WEST SUSSEX COUNTY COUNCIL CONSULTATION

TO:	Arun District Council FAO:Amber Willard
FROM:	WSCC - Highways Authority
DATE:	23 November 2020
LOCATION:	17 Grosvenor Gardens Bognor Regis PO21 3EY
SUBJECT:	AW/230/20/HH Extended dropped kerb.
DATE OF SITE VISIT:	n/a
RECOMMENDATION:	Advice
S106 CONTRIBUTION TOTAL:	n/a

17 Grosvenor Gardens, Bognor Regis, PO21 3EY

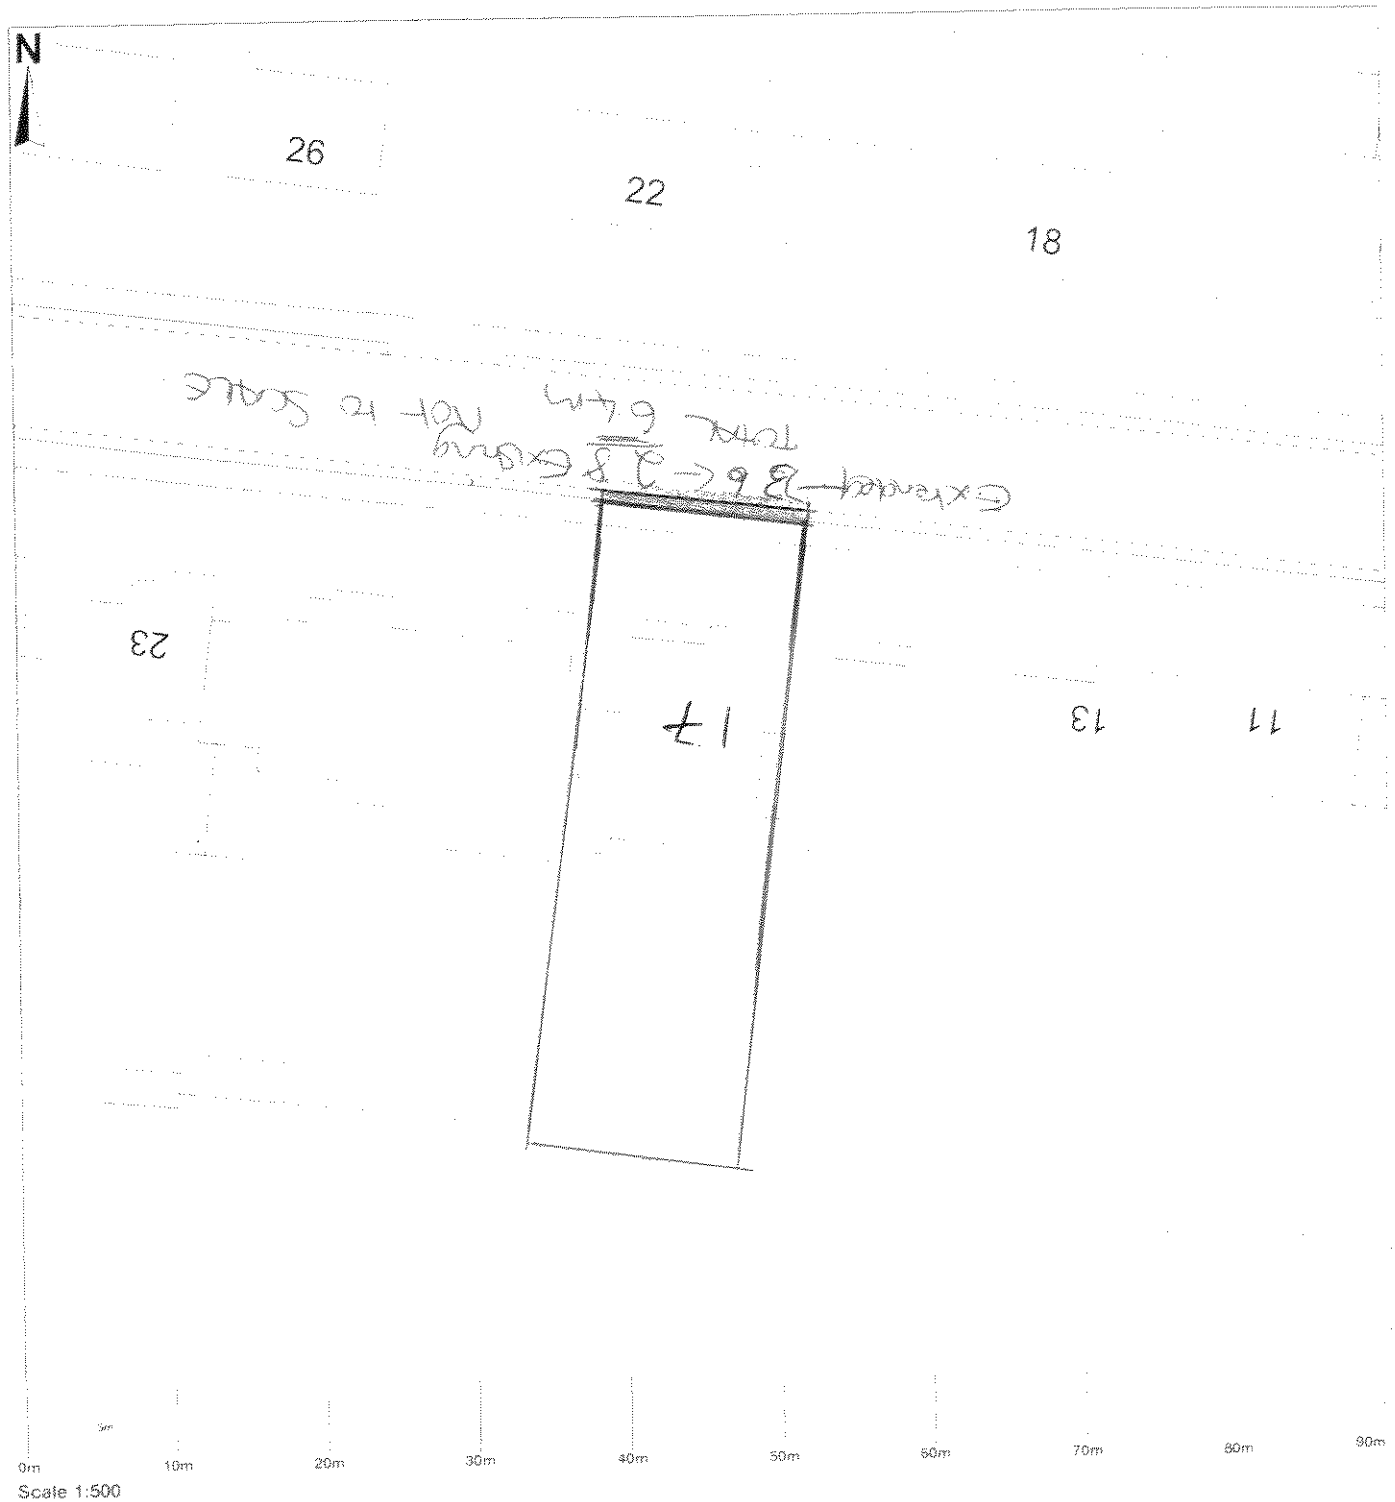
The proposed block plan demonstrates extension to west of the existing vehicle crossover (VCO) resulting in total VCO width of 6.4m. Local mapping indicates that the access benefits from adequate visibility splays in each direction.

The use of the access shall not commence until such time as the vehicular access serving the development has been constructed in accordance with the details shown on the Block Plan.
